**Consultation Response from KC,
Trees**

2025/91348 2, East Street, Batley, WF17 5QY

Erection of two storey side extension

Date Responded: 25/07/2025

| Site plan | |

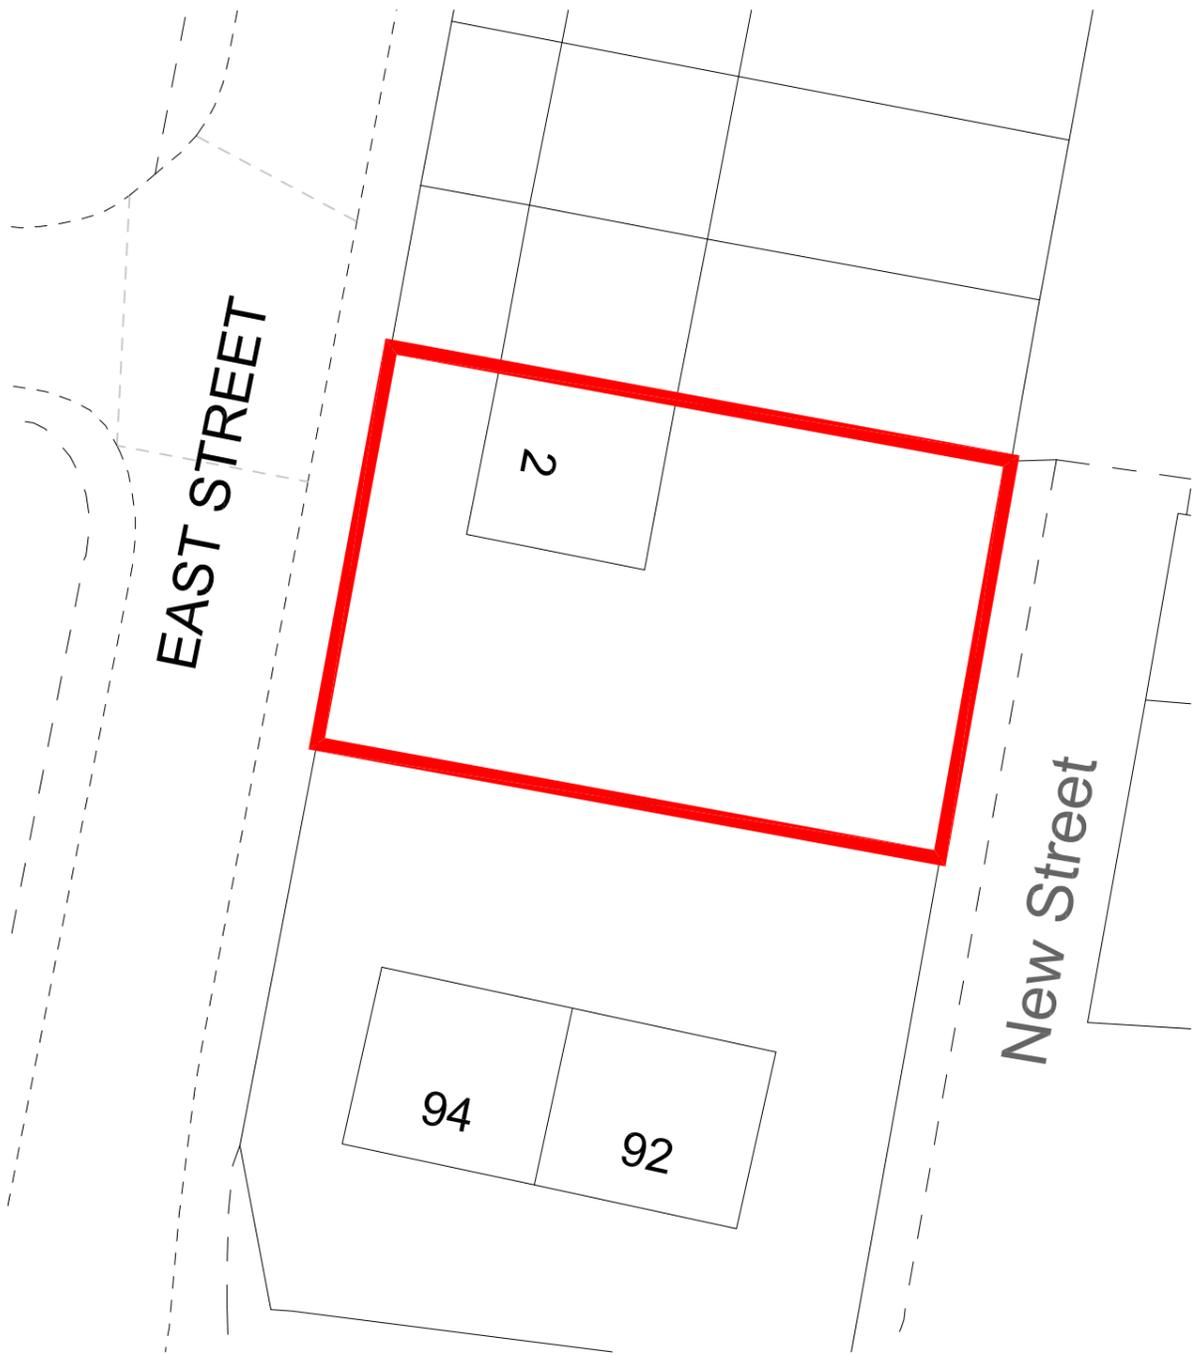
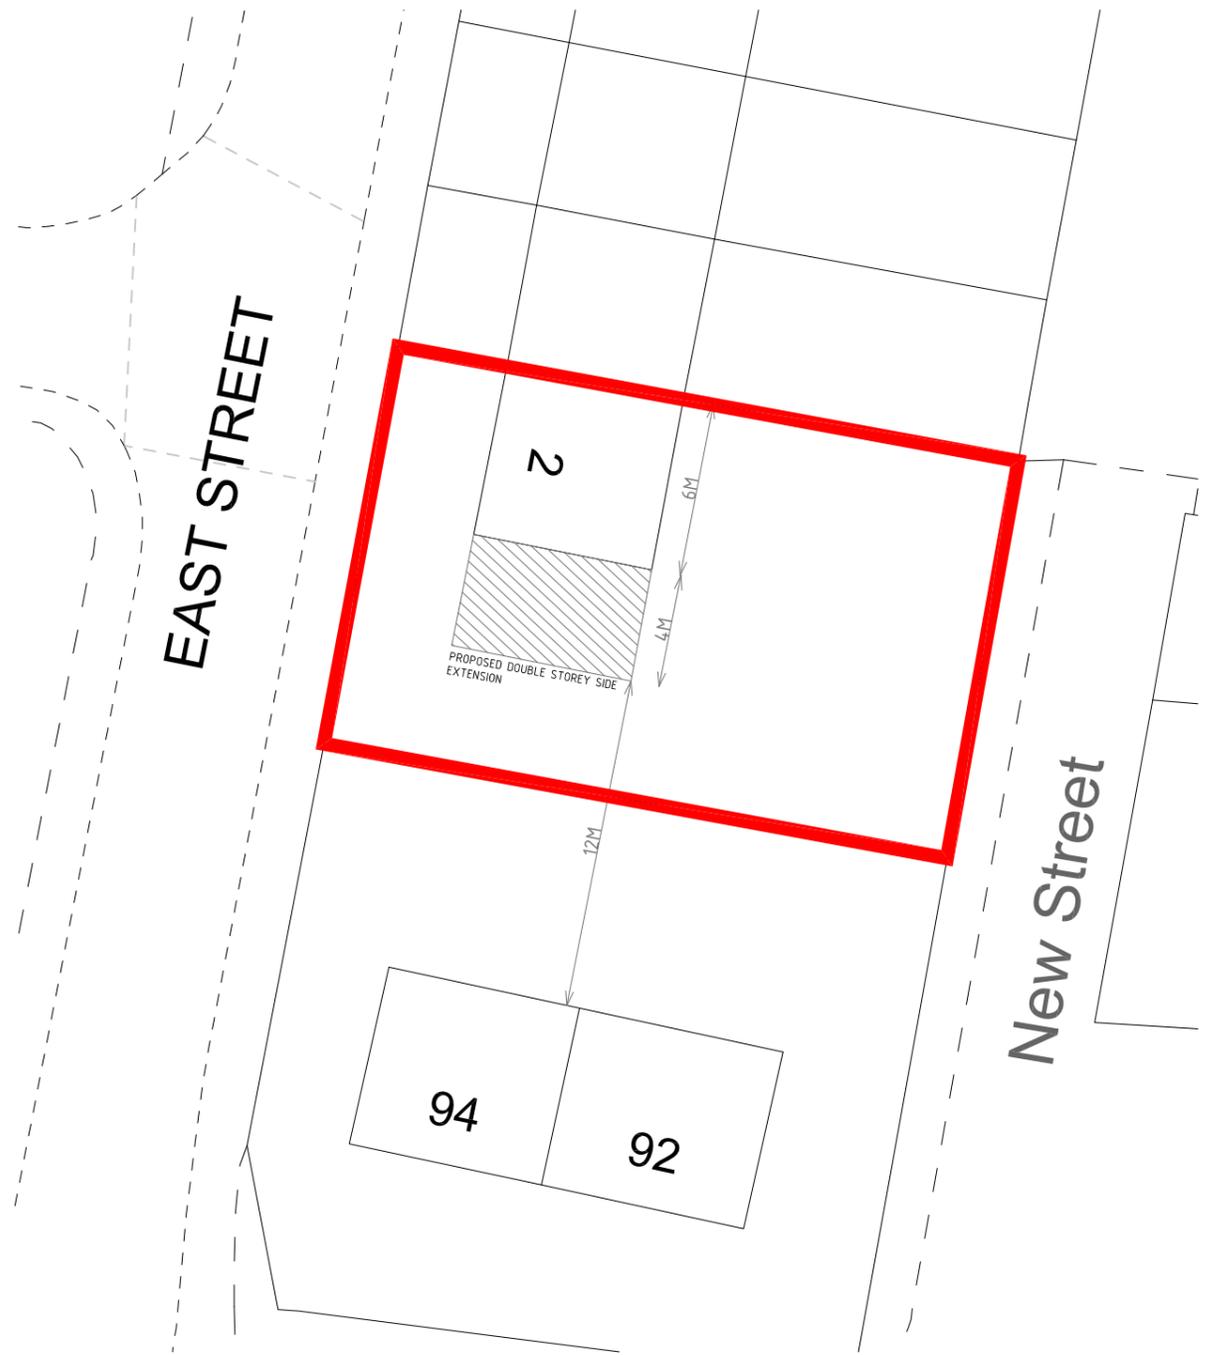
There are no TPOs affected trees on or adjacent to the site and the site is not located within a Conservation Area. However, there is a line of trees on the southern boundary which could be impacted by the development. The ownership of these trees must be established.

There is a holding objection from an arboricultural perspective. The proposal conflicts with adopted Kirklees local plan policy 33 and 24 (i).

- A survey of the trees located on, and immediately adjacent to, the site and/or can influence the proposed site. To include assessment of the condition of the trees and their retention value.
- An Arboricultural Impact Assessment. Which should incorporate a realistic assessment of the probable impact of any proposed development on the trees and vice versa. To include but not limited to; assessments of the factors set out in section 5 of BS 5837; plan overlaying the proposals with tree constraints including shade patterns; evaluation of impact of proposed losses and necessary pruning; draft tree protection plan.
